**From:** April Collinson <readparishcouncilclerk@gmail.com>  
**Sent:** 05 January 2023 16:56  
**To:** Planning  
**Subject:** Re: Consultation on planning application 3/2022/1129 Bridge Hey Wood Caravan Park, Dunkirk Farm, Read BB12 7RR

The application is for retrospective change of use with minor engineering works and associated landscaping works for the reuse of the former railway embankment and track bed to form an informal recreational amenity area in association with the adjacent holiday park.

Earth bund and bench seating
Scale 1:200

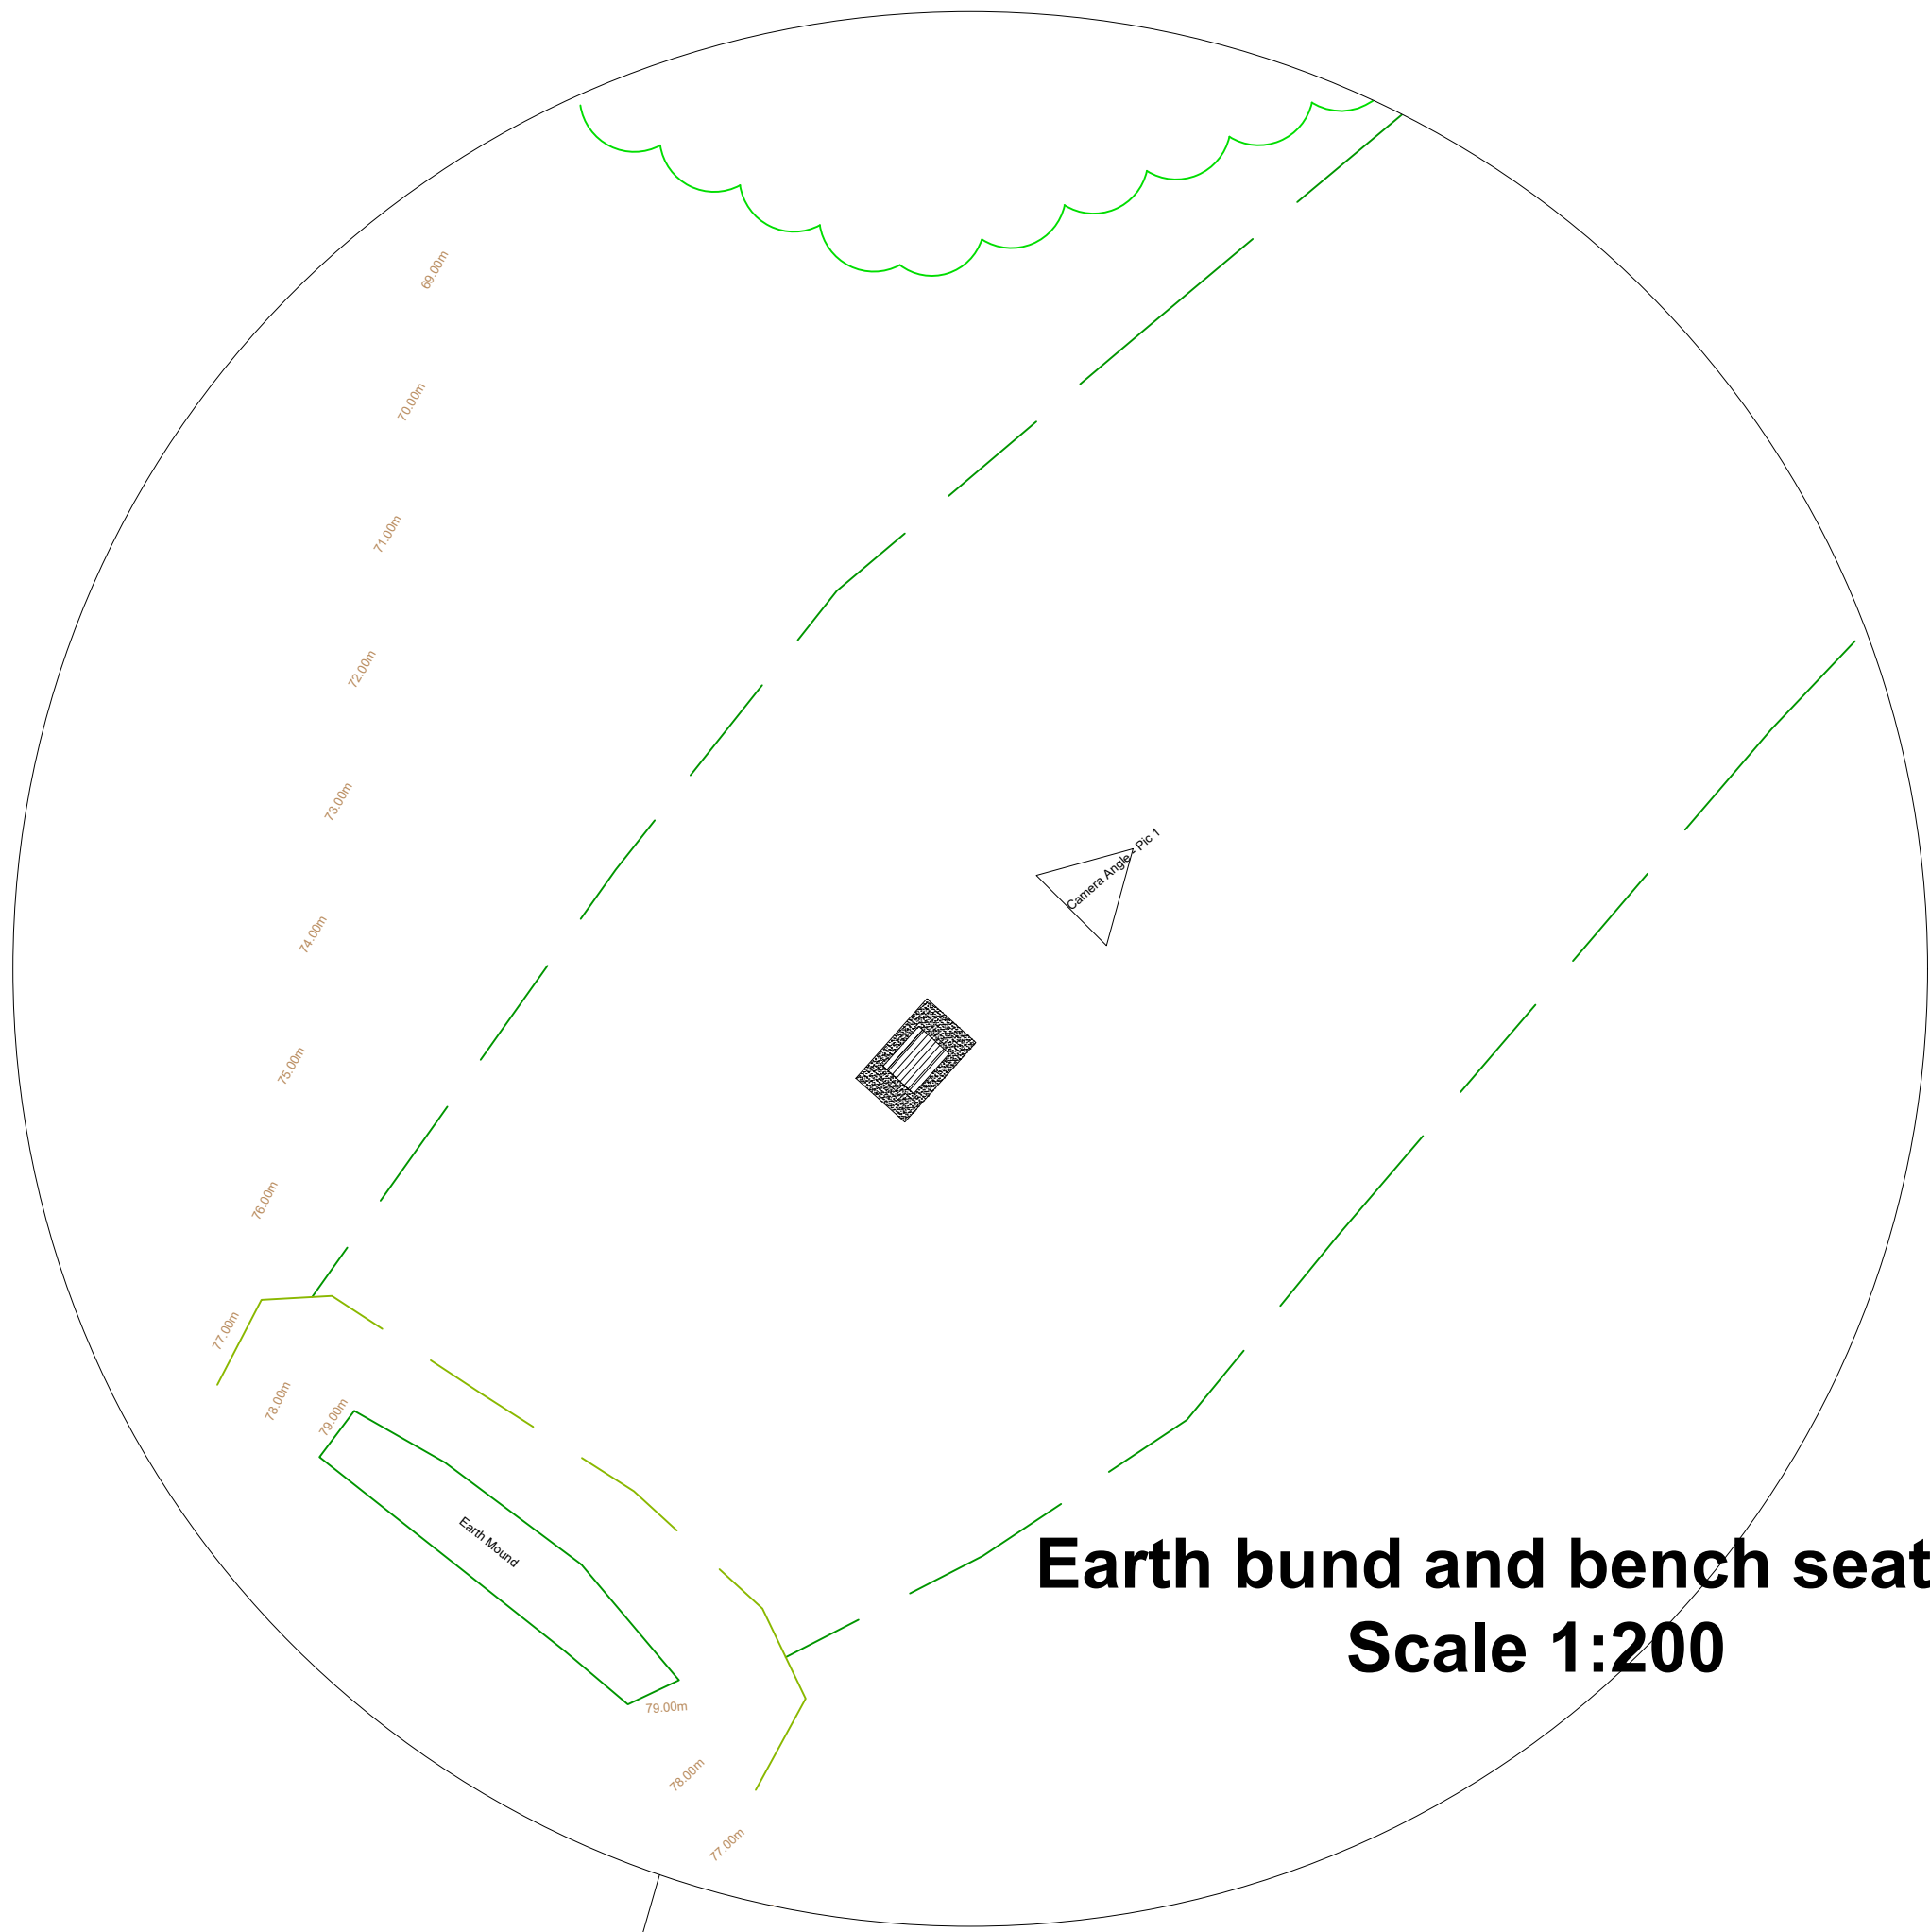
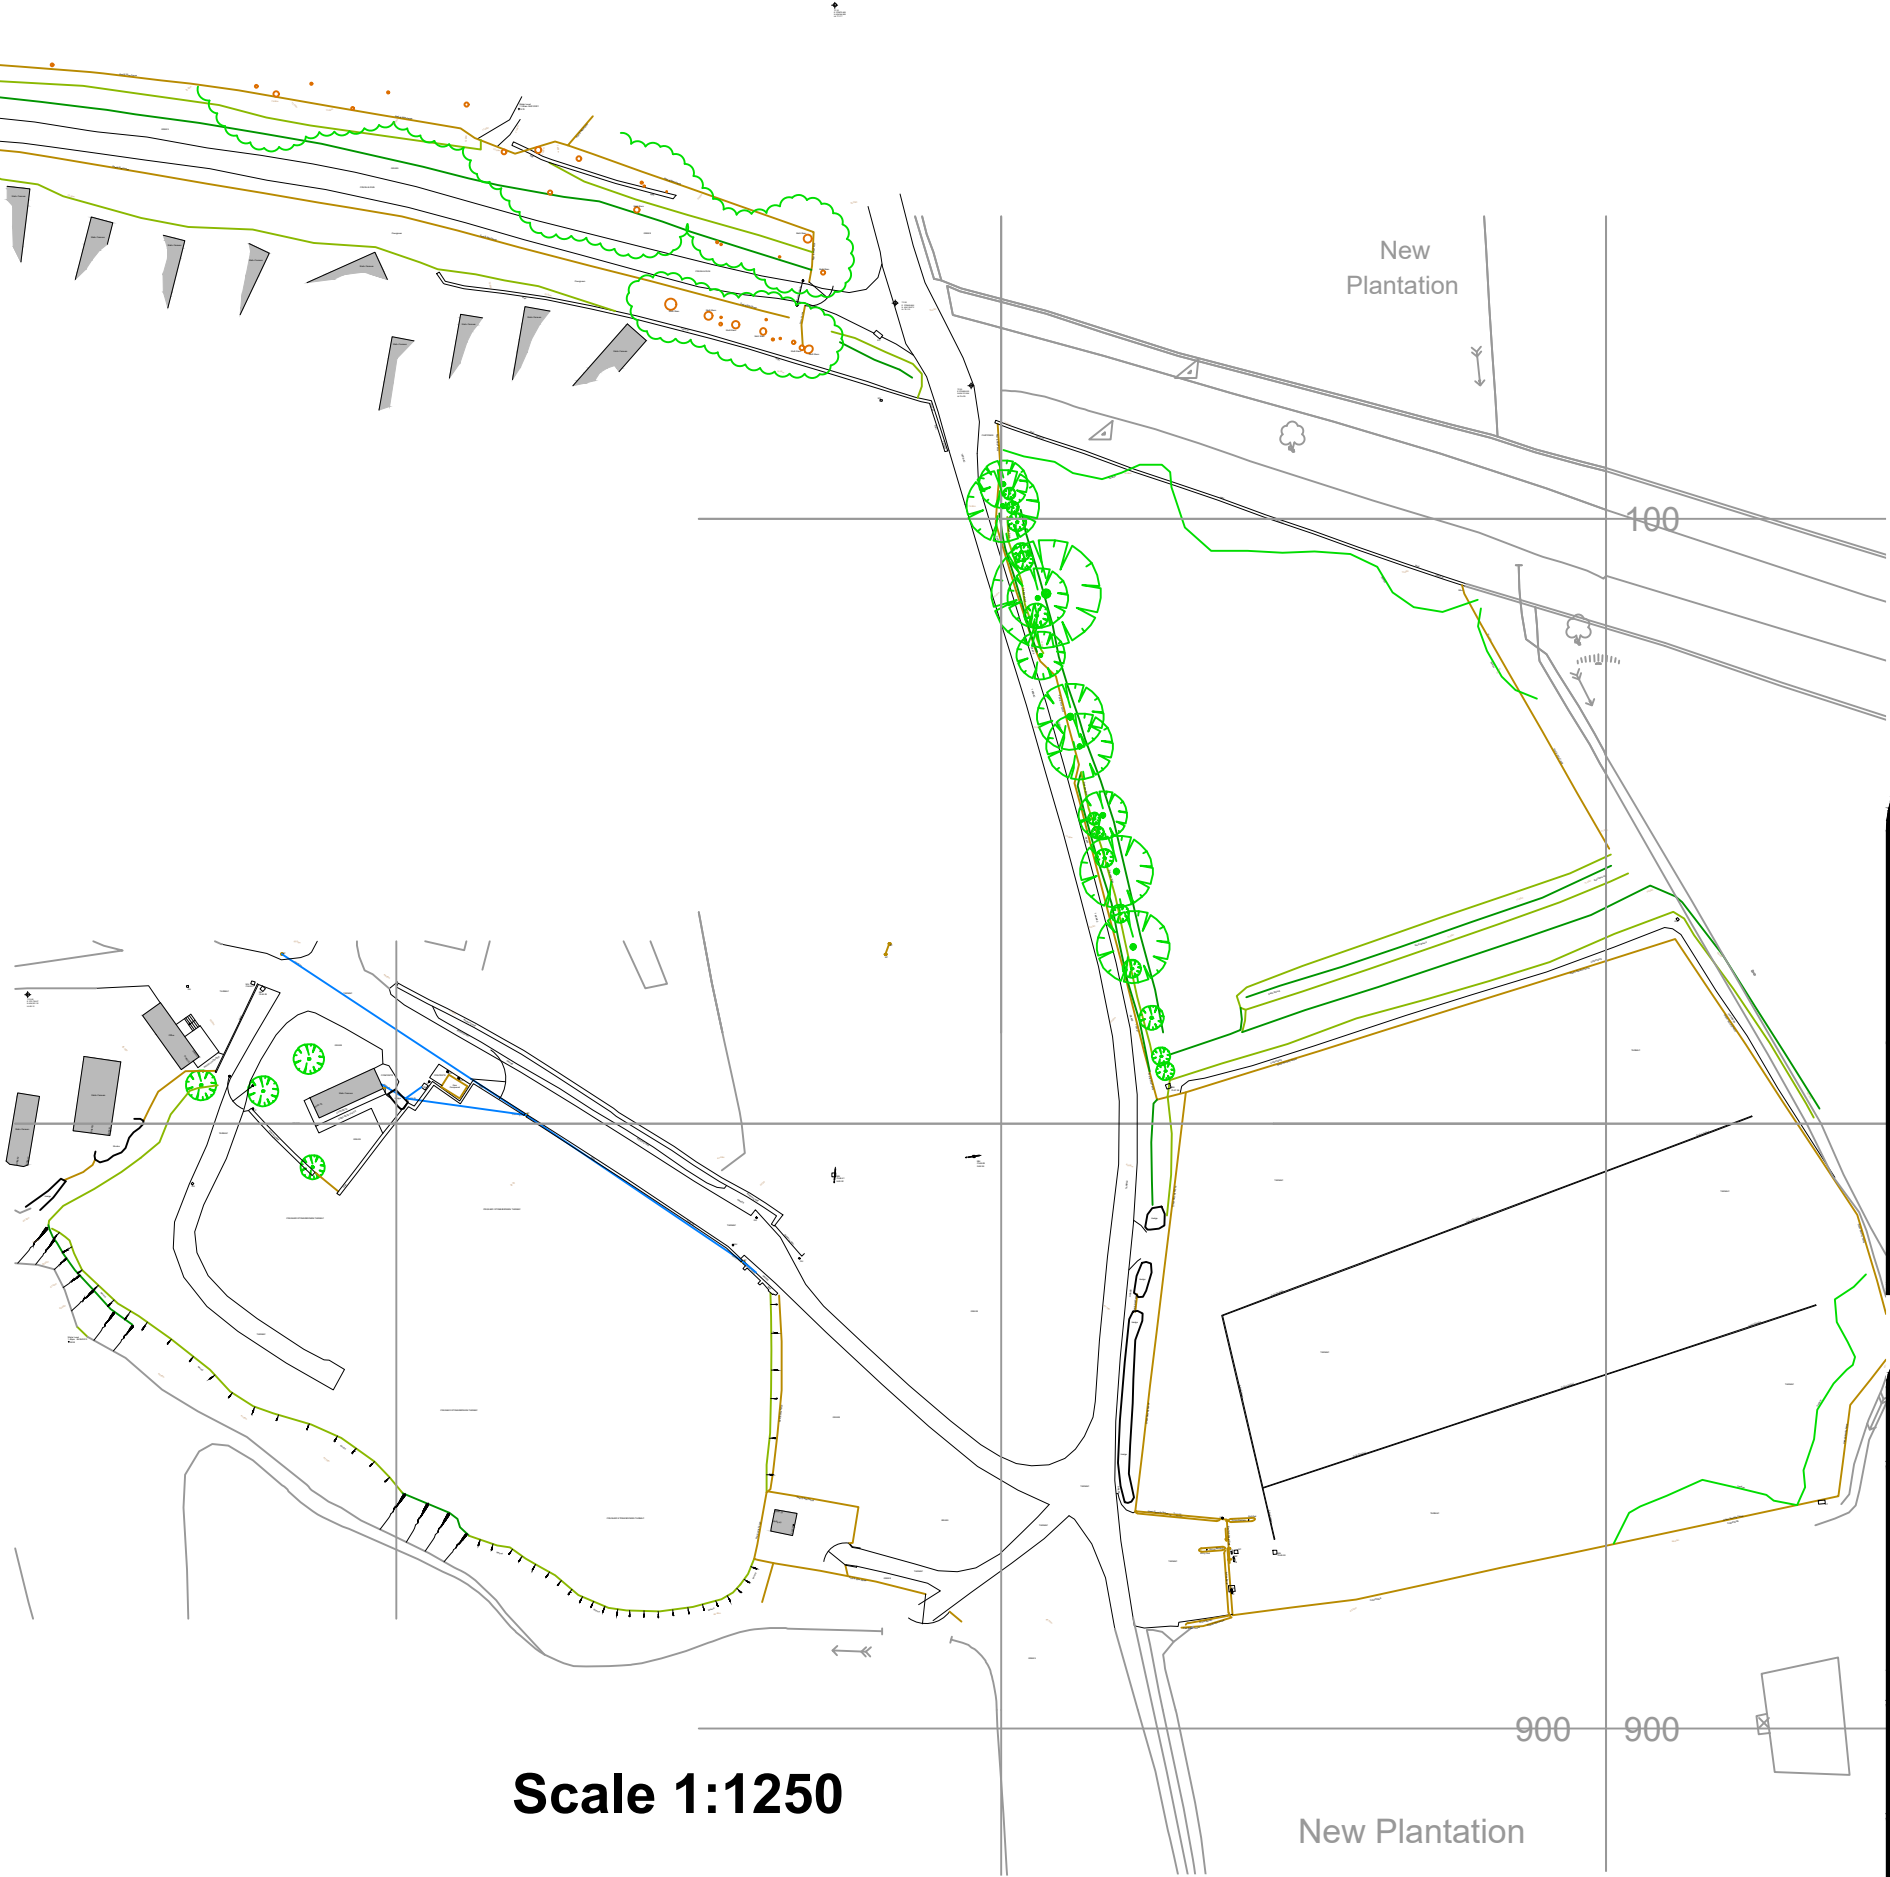
3. The Ditch and Bund formed block access to the Viaduct which is necessary for Railway Paths to perform maintenance on the Viaduct and ensure safety. This provides no additional protection from trespass as there is already a large metal fence in place. This right of access is noted on the land registry documentation (dated 12.10.1979). The ditch also holds potential to cause damage to the viaduct itself.
